RE: Proposed IMAX, Darling Harbour redevelopment (SSD 5397)
Submission to proposed development

This submission is prepared on behalf of the PARKROYAL Hotel, Darling Harbour (150 Day Street, Sydney), in relation to the proposed entertainment, retail and commercial redevelopment of the IMAX site.

DRAWING TITLE  
 GA ELEVATIONS - SHEET 4

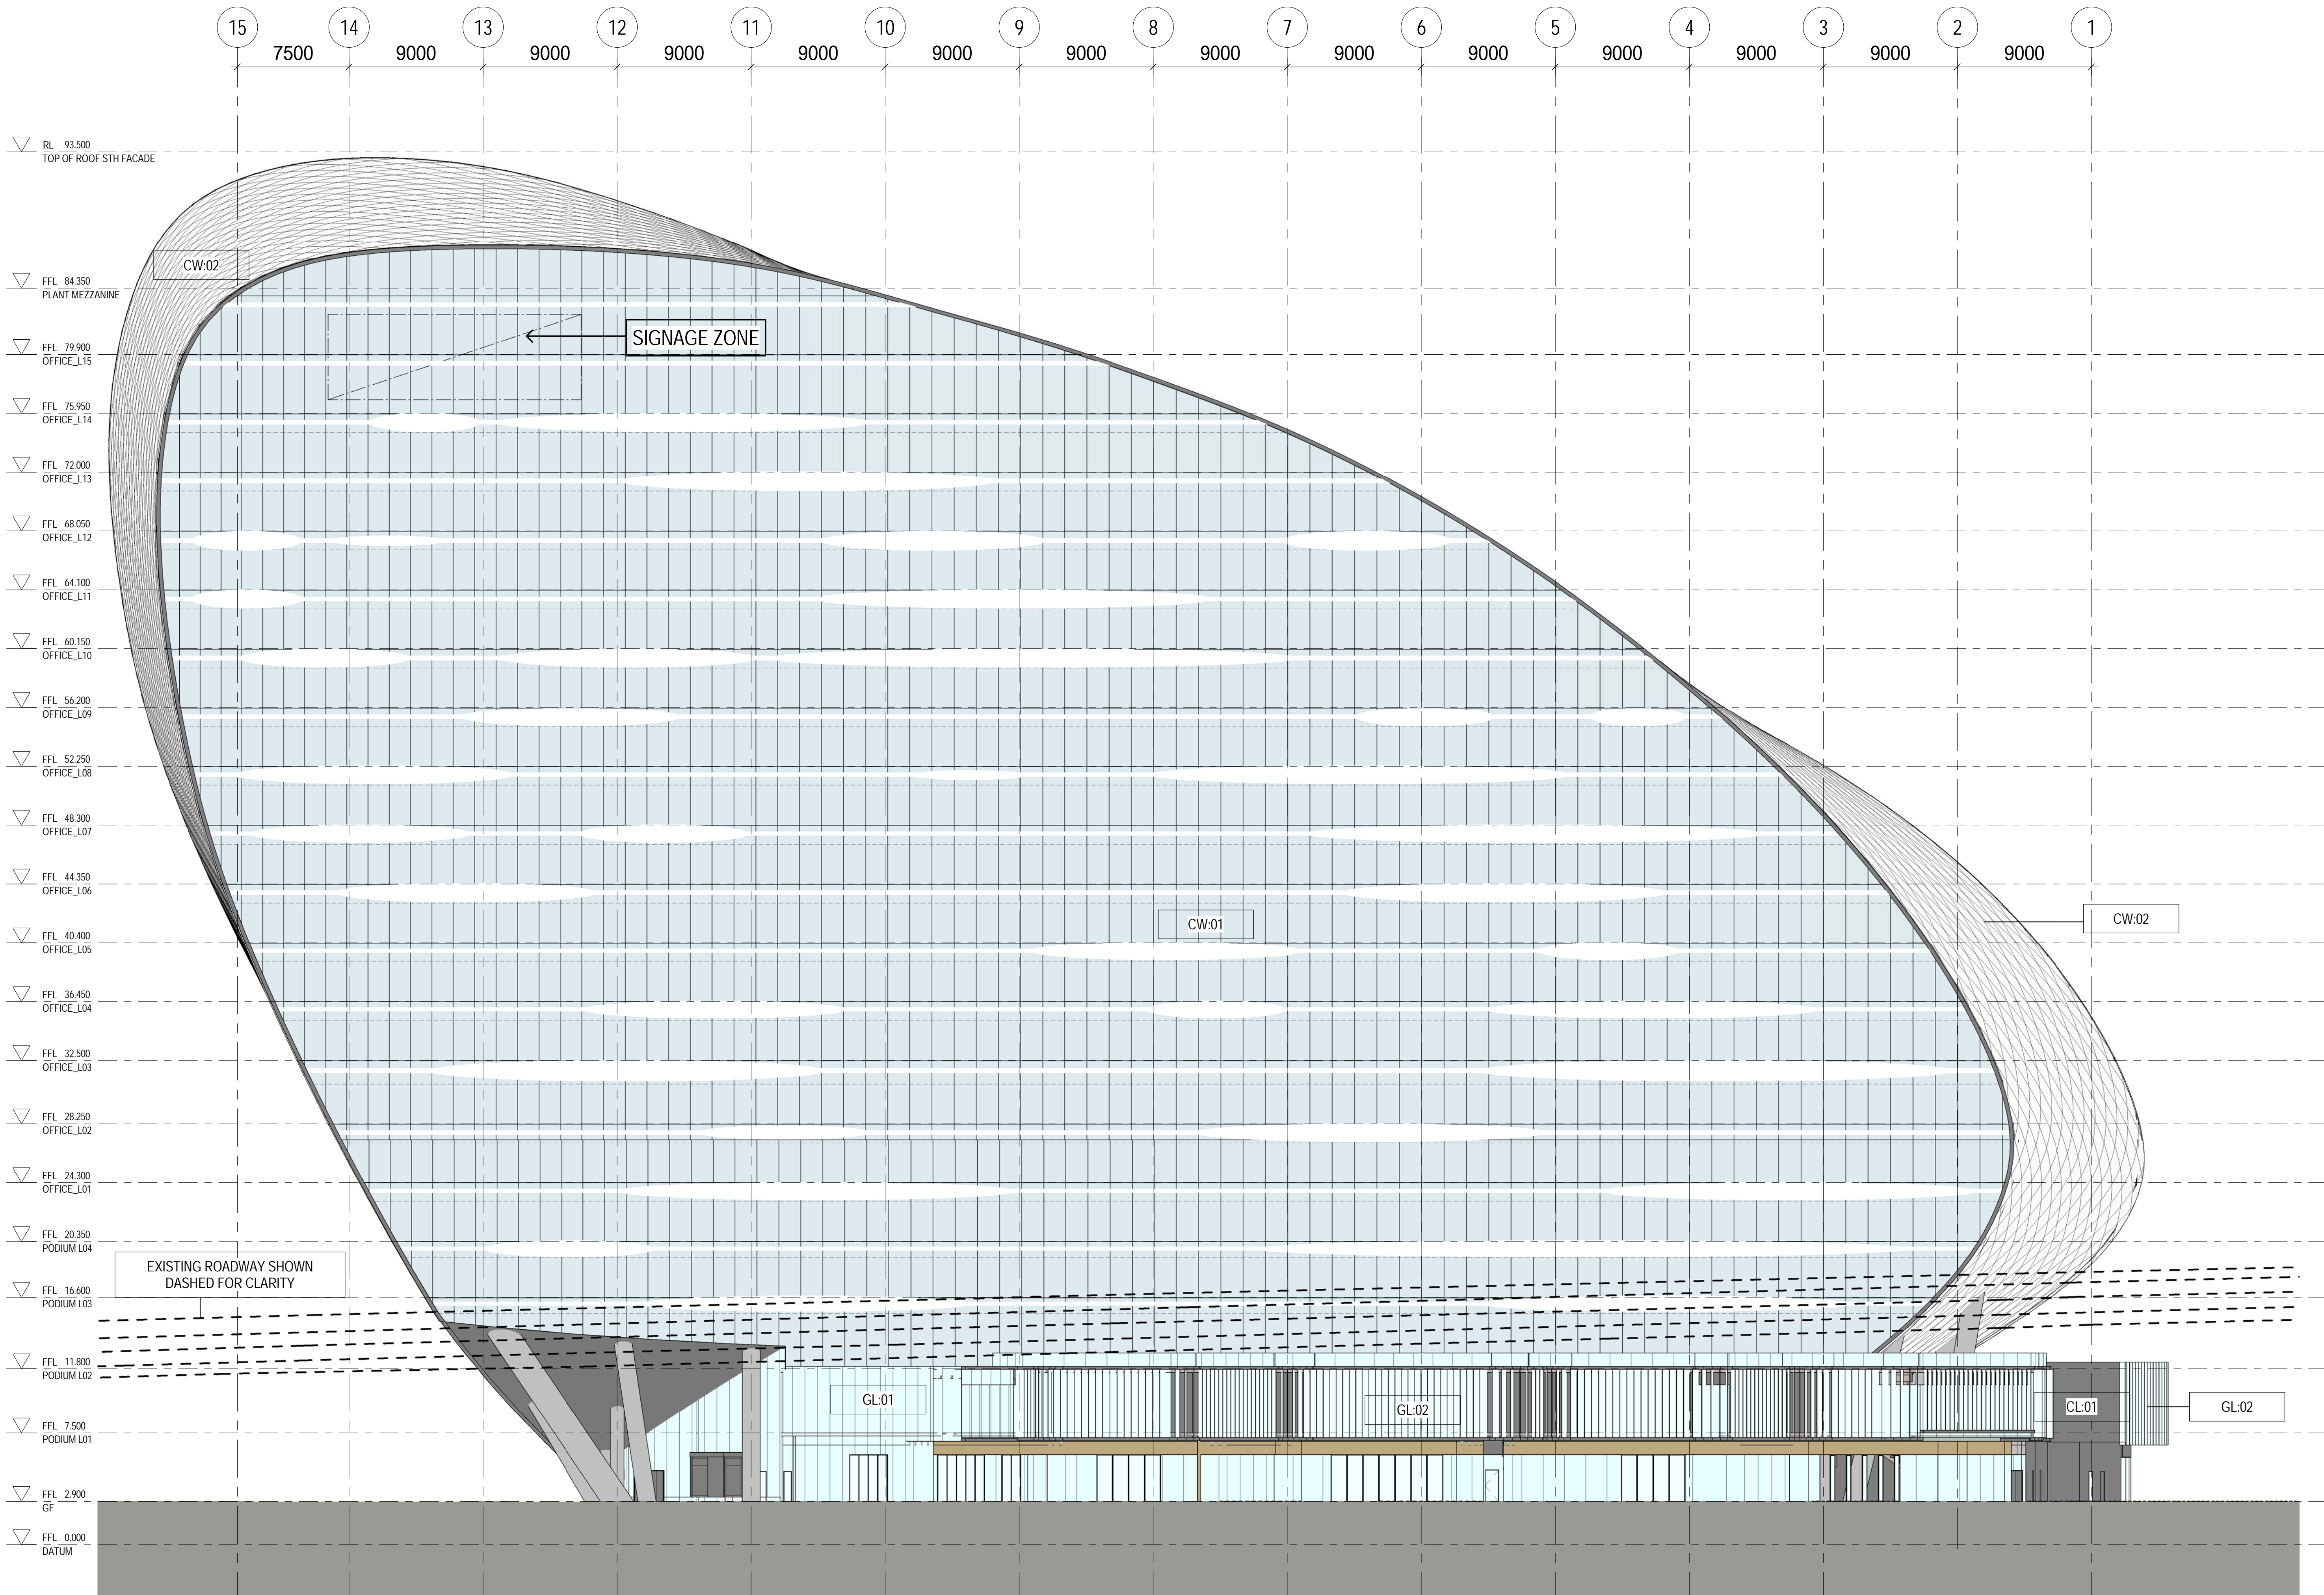
The applicant should clarify the potential reflectivity impacts of the proposed development on the surrounding area, as there may be glare issues to the PARKROYAL. The extent and tint of glazing associated with the Ribbon may result in undue reflectivity impacts toward the PARKROYAL Hotel rooms as well as the Club Lounge and Restaurant (particularly around breakfast and lunch times). High reflectivity toward these parts of the hotel will have significant impact on the amenity of hotel rooms and the club lounge and restaurant. It is recommended that further reflectivity analysis be undertaken from the Club Lounge and Restaurant of the hotel, to ensure reflectivity does not exceed 20%.

The proposed location, type and illumination of future signage are not indicated in this development application. High level illuminated signage on the eastern face of the development will likely have detrimental impacts on the amenity of west facing hotel rooms. The plans should identify locations for future signage, and conditions should be imposed to restrict the illumination and size of signage to ensure there is no detrimental impact on hotel patrons and the surrounding area.

3. The proposed location of signage should be identified on the architectural drawings. The size of signage should be such that it does not detract from the overall building design and the outlook provided to west facing hotel rooms, the Club Lounge and the Restaurant of the PARKROYAL Hotel.
